Your Ref: OWPC20482
Our Ref: BR/222/18/PL 02-08-2018
Please ask for:
Mr S Davis

Erection of 4no. 2 bedroom dwellings with associated parking & landscape.
Land adjacent to Community Centre Westloats Lane Bognor Regis

Thank you for your internet representation made on 8th November 2018 which has been recorded as '**an objection**' with the comments as follows:

UNITS 1-4 PLANS

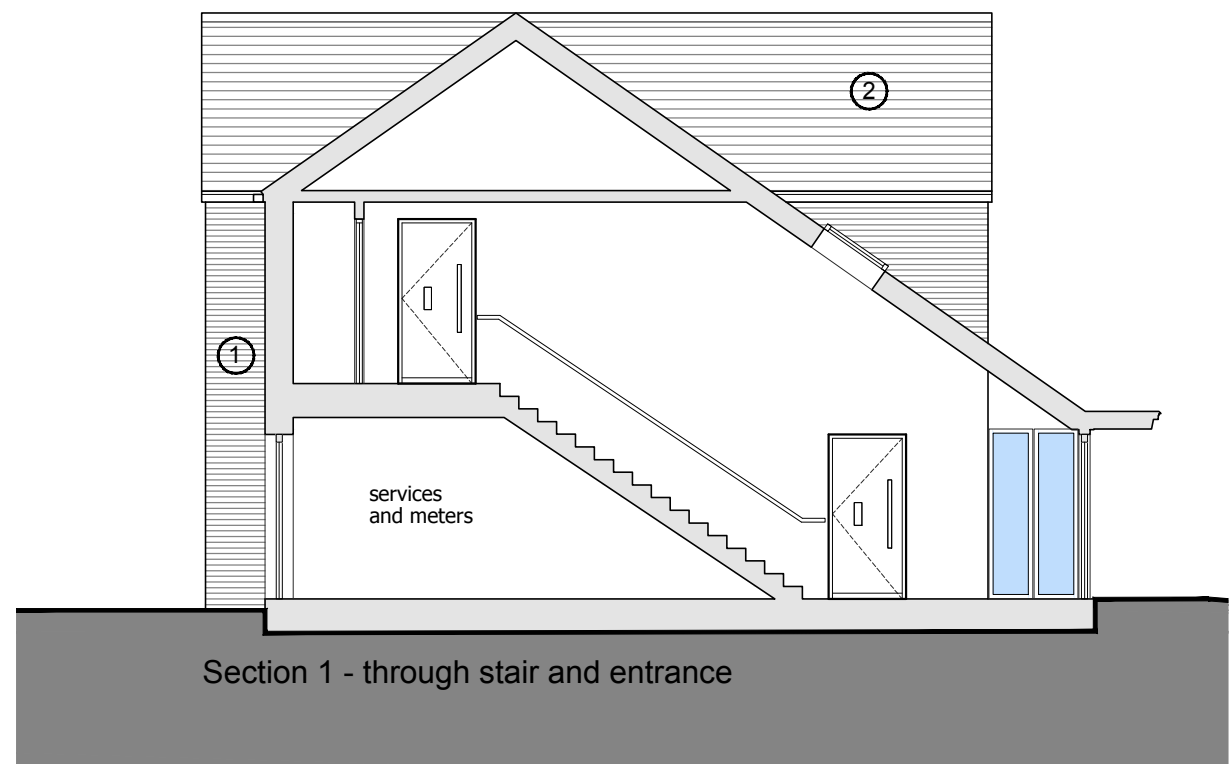
- Overlooking/Mainly loss of privacy. The proposal is for two storey building.

Northern facing secondary 1st floor lounge window should be removed to stop overlooking our garden. We have bought our house because it has got this beautiful garden where we have enjoyed our time in private.

In planning application are gables which I think should be replaced with sloping tiled roof to lessen the impact.
